December 10, 2018

RE: Drainage Easement – Gleneagle Golf Course Infill Residential Development Filing No. 2  
15070 Westchester Drive – Lot 7, Block 3, Donala Subdivision Filing No. 1

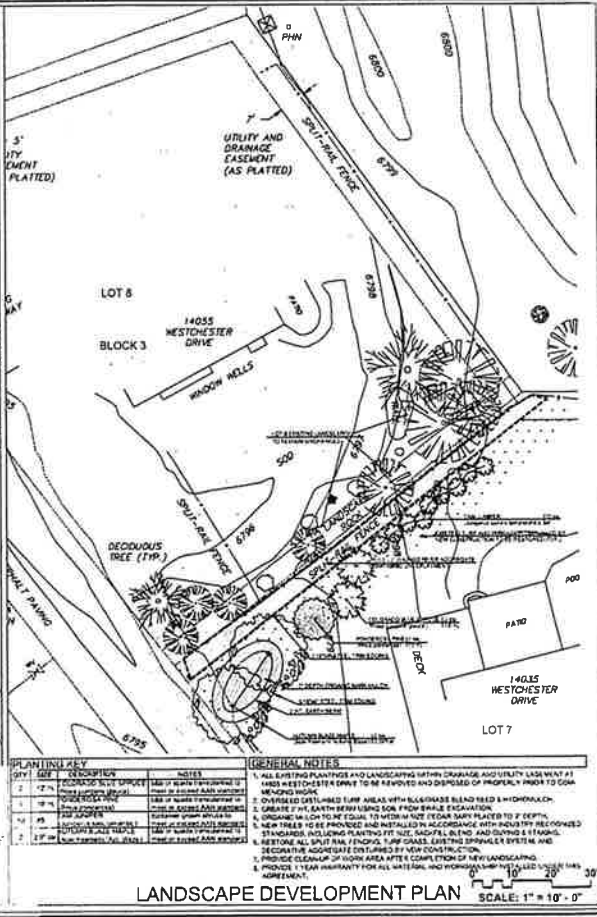
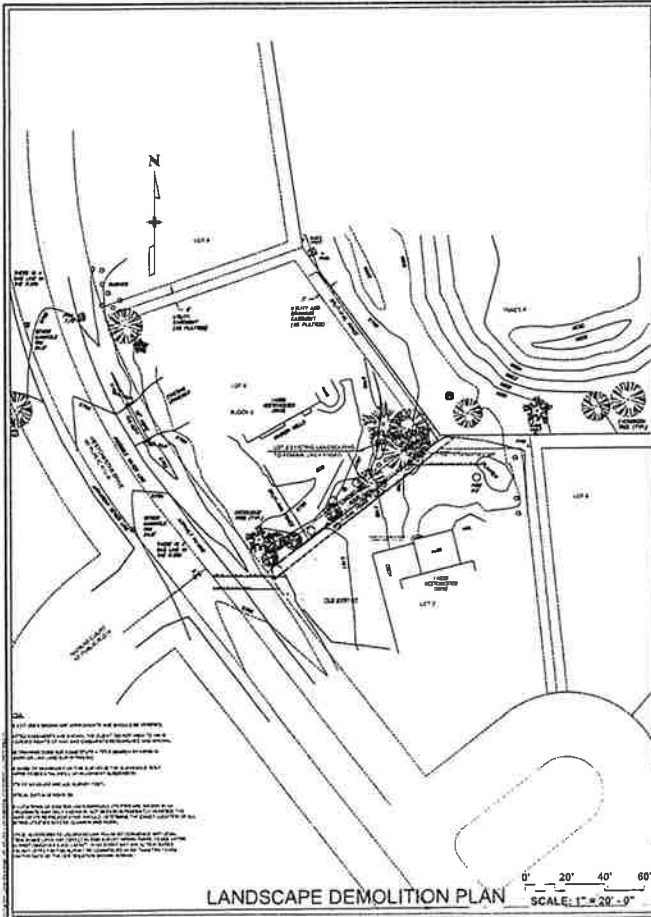
The attached documents identify Lot 7 as 14035 Westchester, also there is no identified dimensions on the attached documents. Is there an exhibit missing (the easement document)?
